Arun District Council
Arun Civic Centre
Maltravers Road
Littlehampton
West Sussex BN17 5LF
Planning & Building Control General Enquiries
Tel: (01903) 737756 Fax: (01903) 730442
Dx: 57406 Littlehampton
Minicom: 01903 732765
e-mail: planning@arun.gov.uk
website: www.arun.gov.uk/planning

Application No: EP/163/21/HH
Site Address: 4 Selhurst Close East Preston BN16 2SR
Description of works: Single storey front extension, conversion of integral garage and new detached garage.

Thank you for your internet representation made on 12th December 2021 which has been recorded as an objection with the comments as follows:

Drawing Name
Garage - Proposed

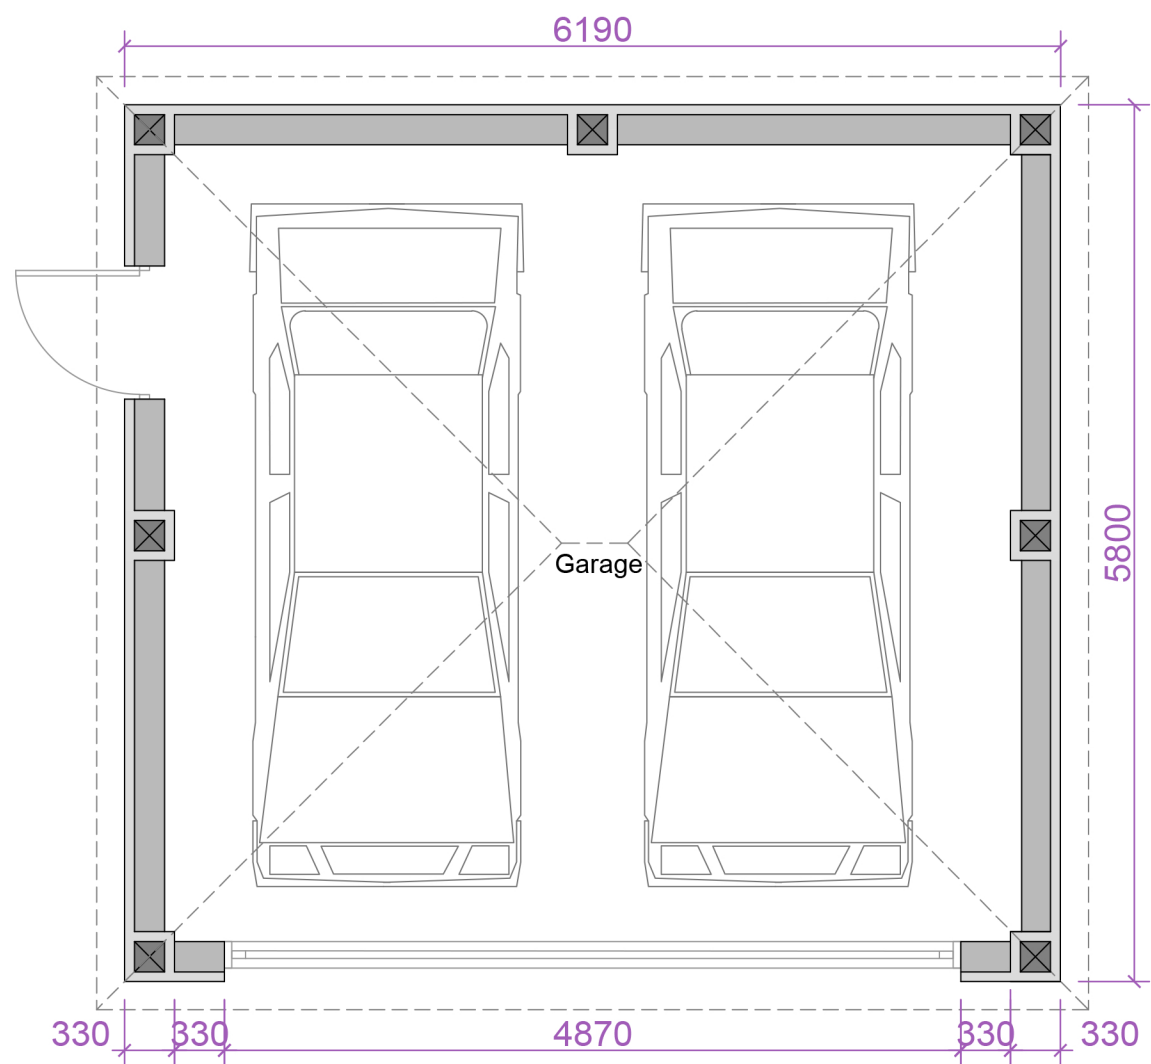
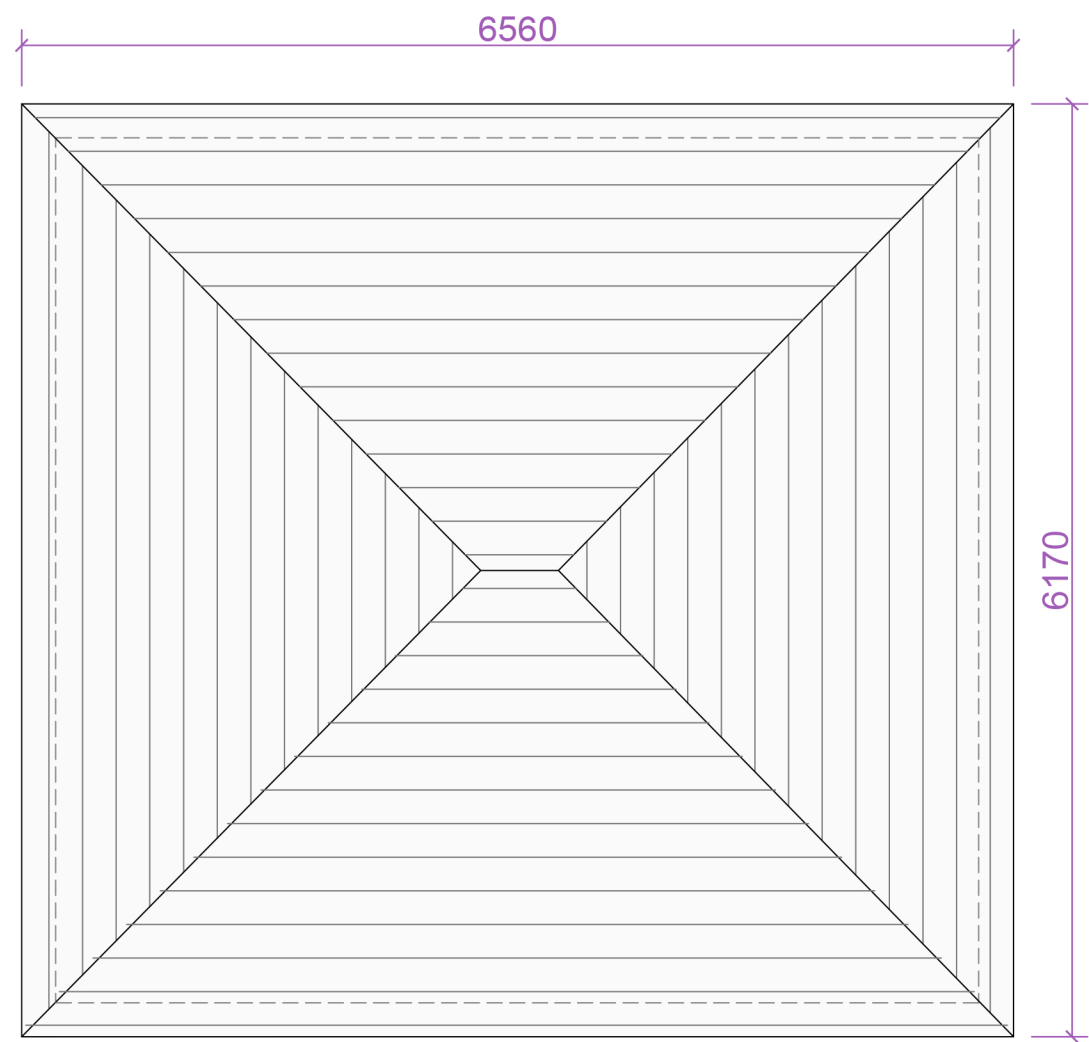
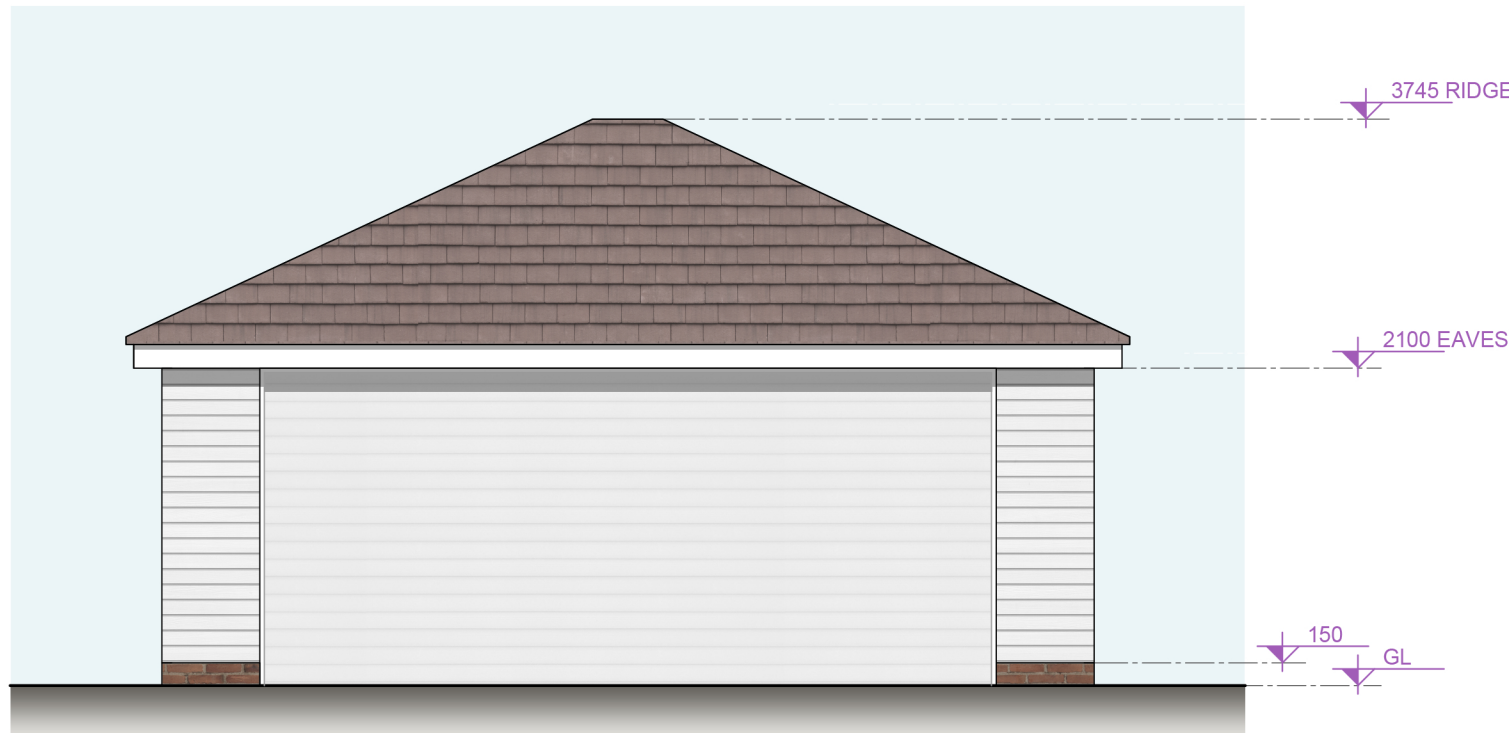
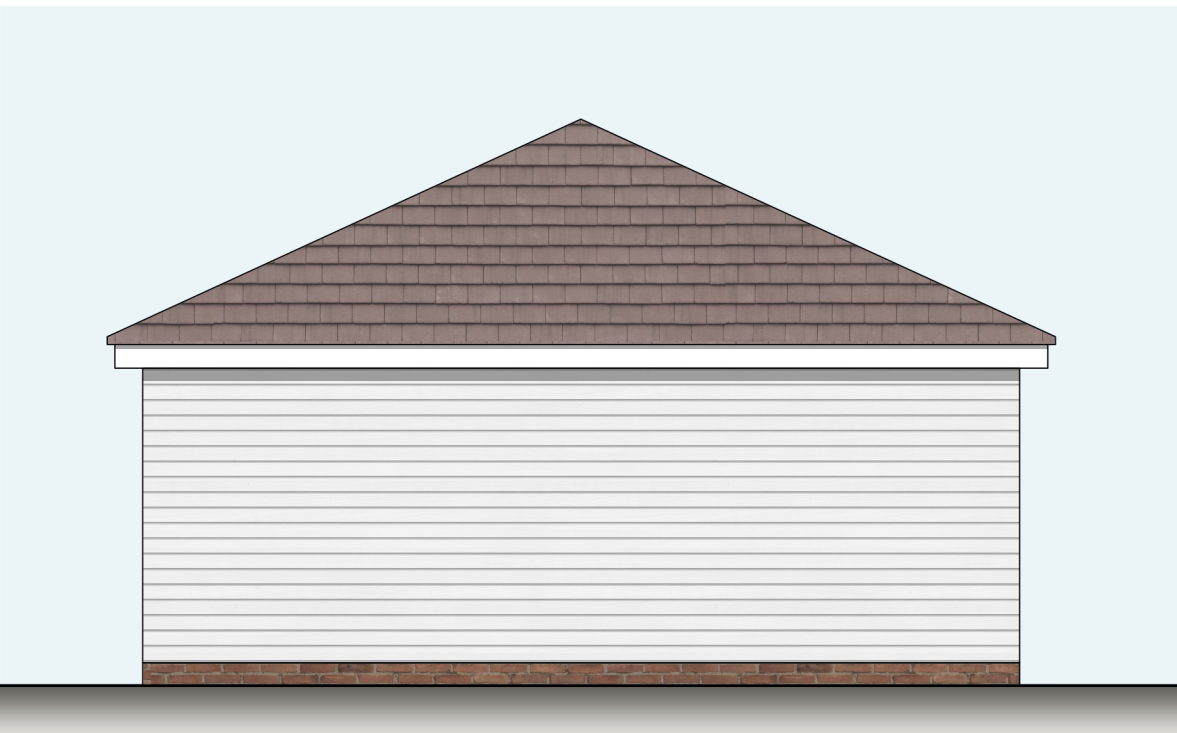
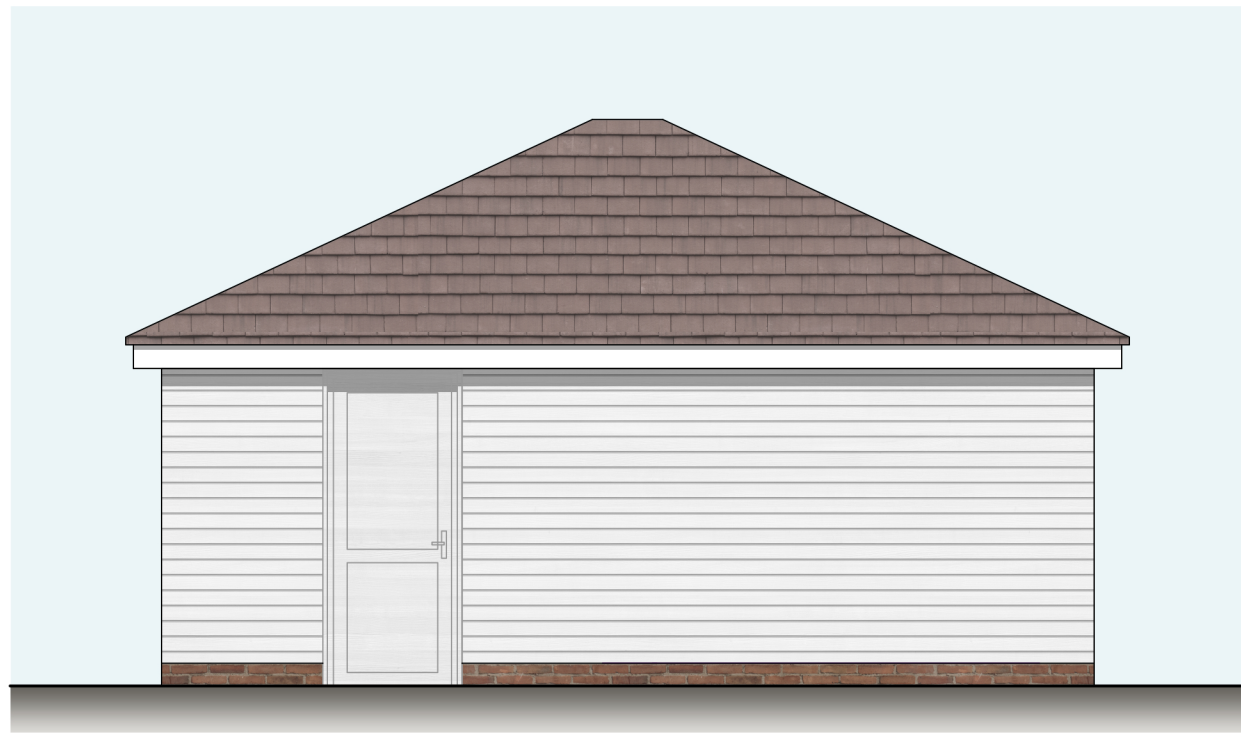
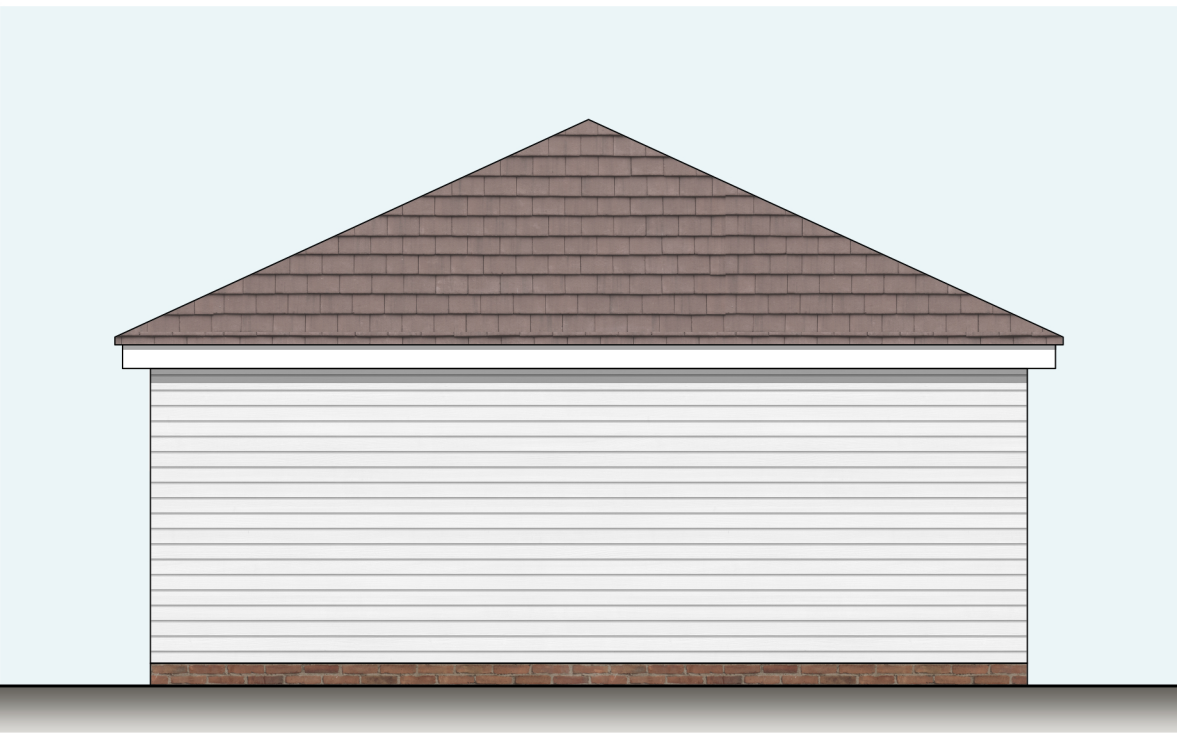
I wish to register an objection to the proposed construction of a separate building, namely a garage block with capacity for two vehicles, in the front garden at Number 4 Selhurst Close, East Preston BN16 2SR. The proposed building would be out of keeping with the established character and appearance of Selhurst Close, where no property has a separate building in the front garden. Furthermore, the proposed building would represent an excessive development of the plot, noting that the original dwelling was a bungalow before being reconstructed as a two-storey house with five bedrooms. I recommend that the application for planning permission for the proposed garage block be rejected.
